**REQUEST**

Current Zoning: N1-A (neighborhood 1-A)  
Proposed Zoning: N2-A(CD) (neighborhood 2-A, conditional)

Approximately 3.52 acres located along the north side Johnston Oehler Road and south of Barrow Road.

The petition proposes to develop a residential community to allow up to 45 multi-family attached dwelling units.

RZ-1.0

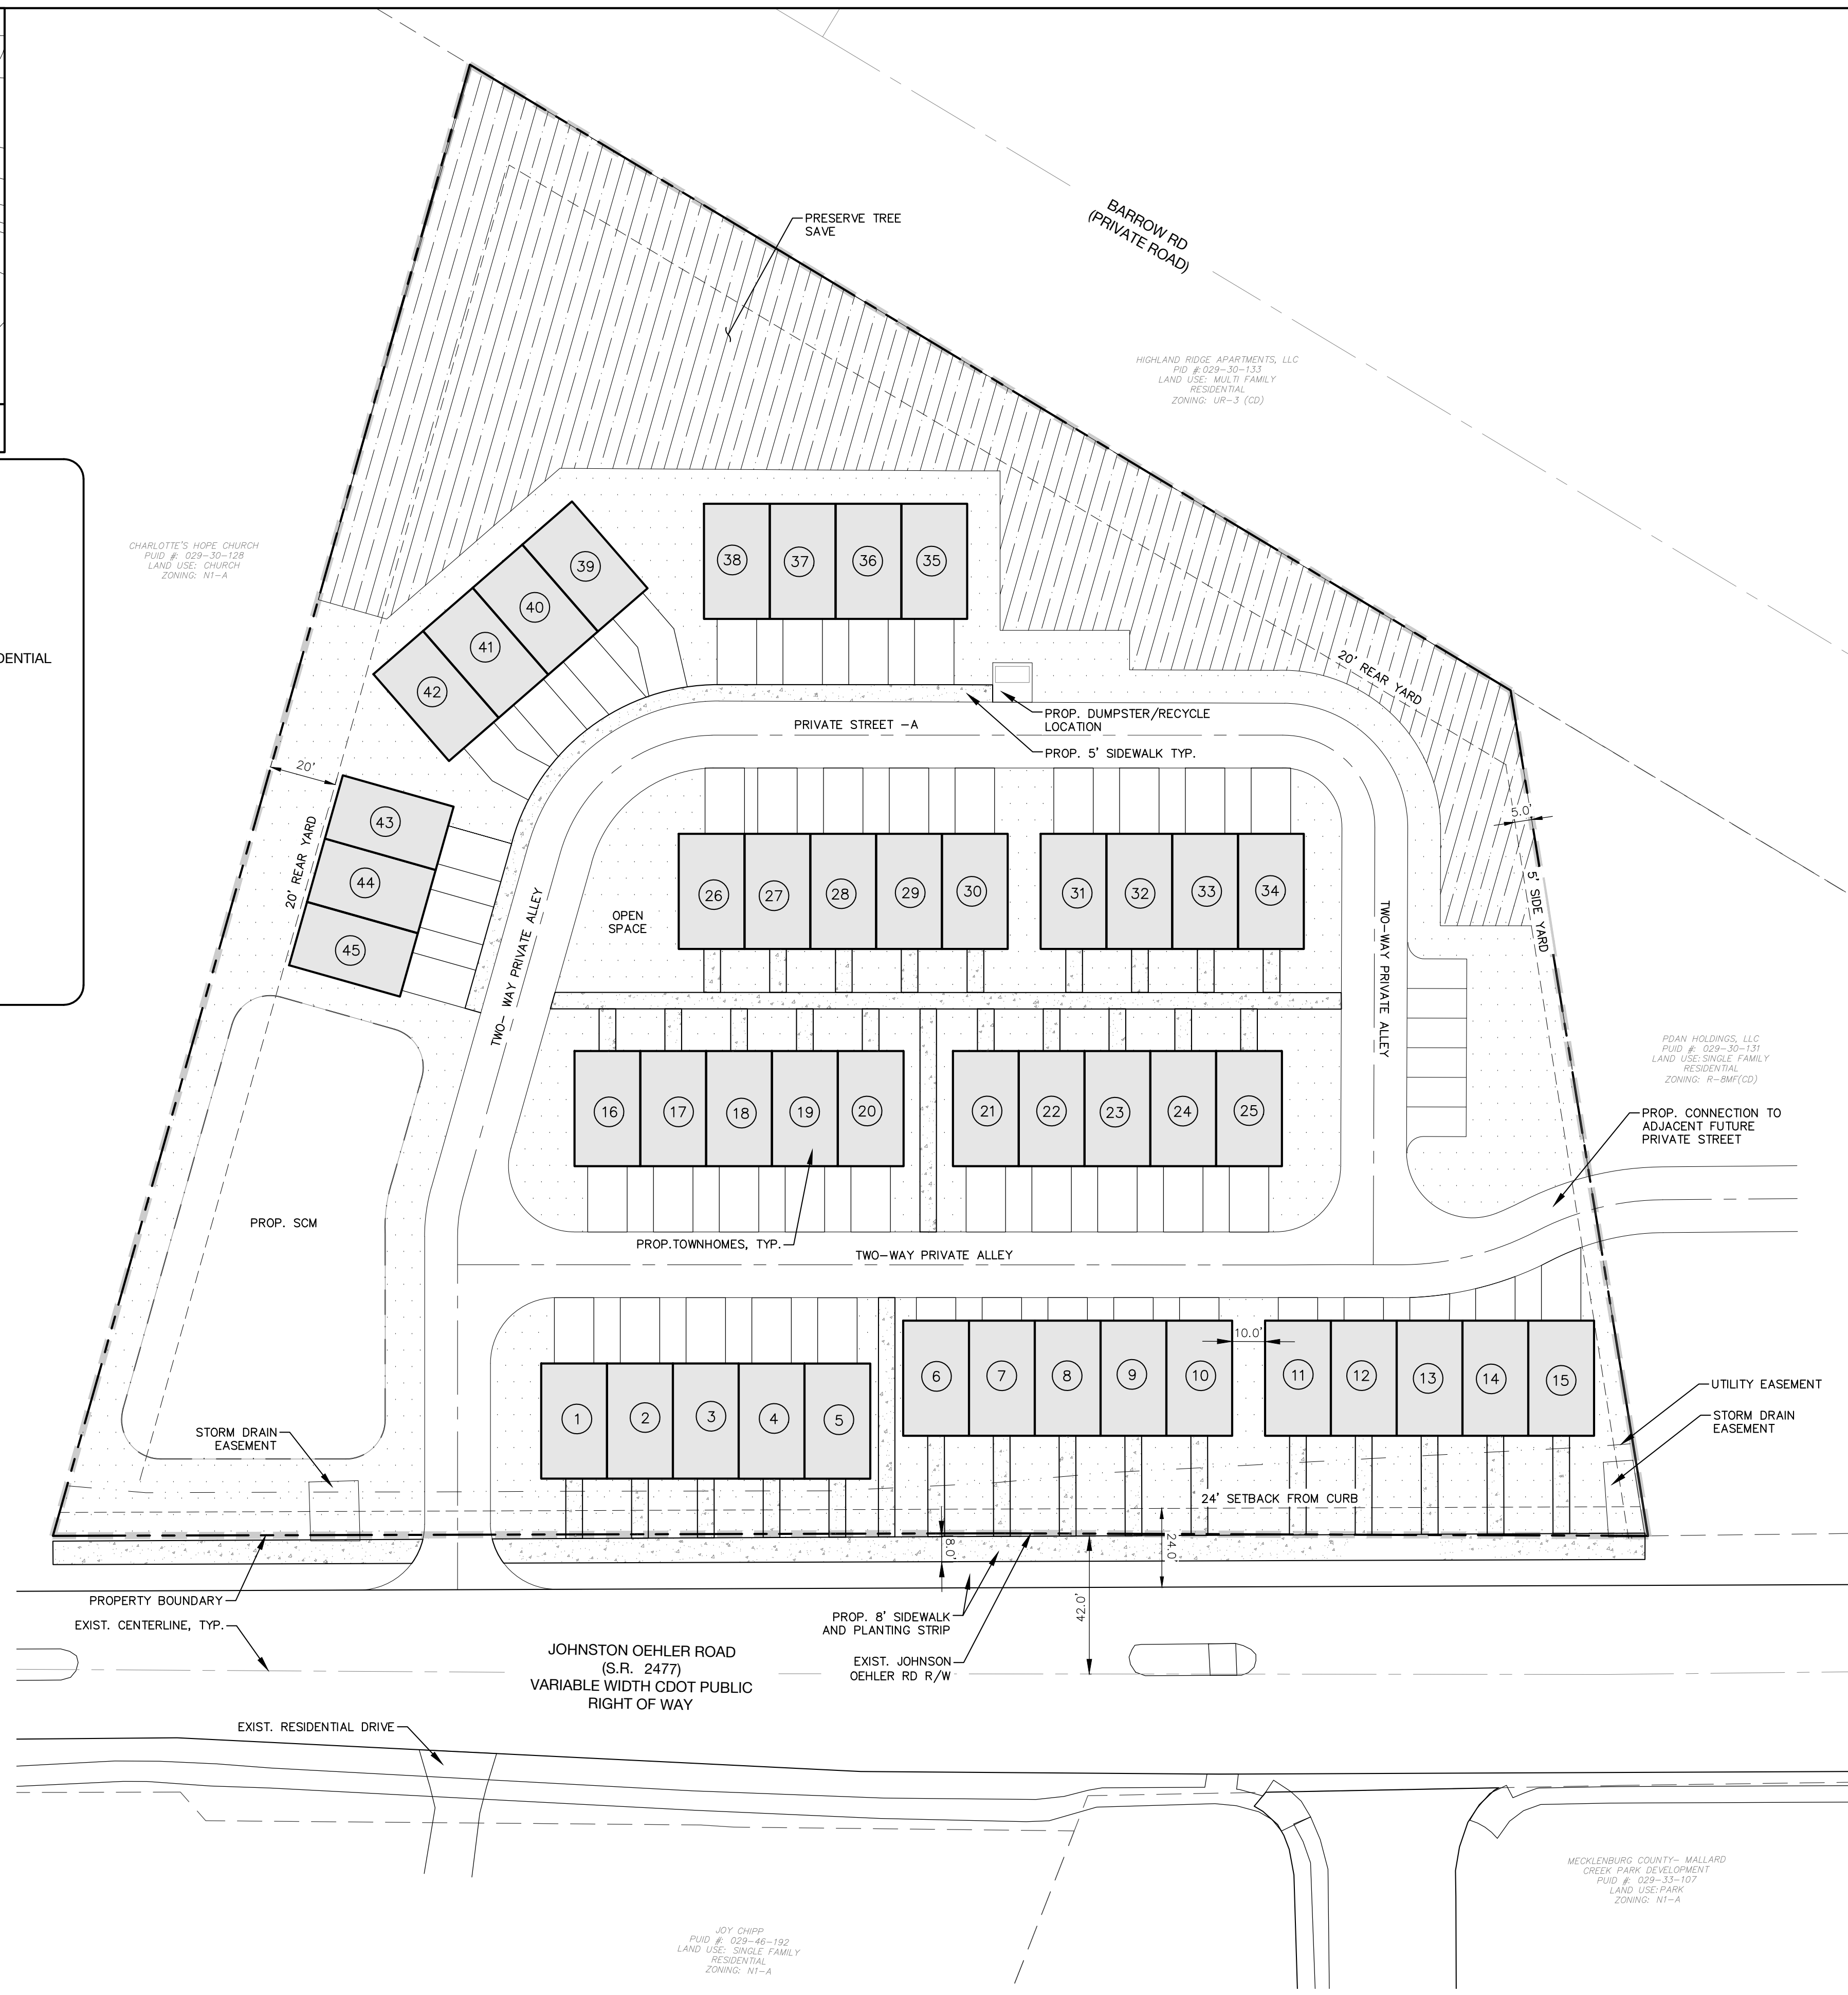
1. Site access is to line up with the residential driveway on the southern side of the roadway. Addressed

2. Revise site plan and conditional note(s) to commit to installing a signalized pedestrian crossing at the existing pedestrian crossing location that would allow for connection to Mallard Creek High School. Addressed
3. Remove conditional note referencing reverse angle parking. Addressed

4. Minimum tree save width for protected area is 30-feet. Addressed
5. Tree survey required. Addressed
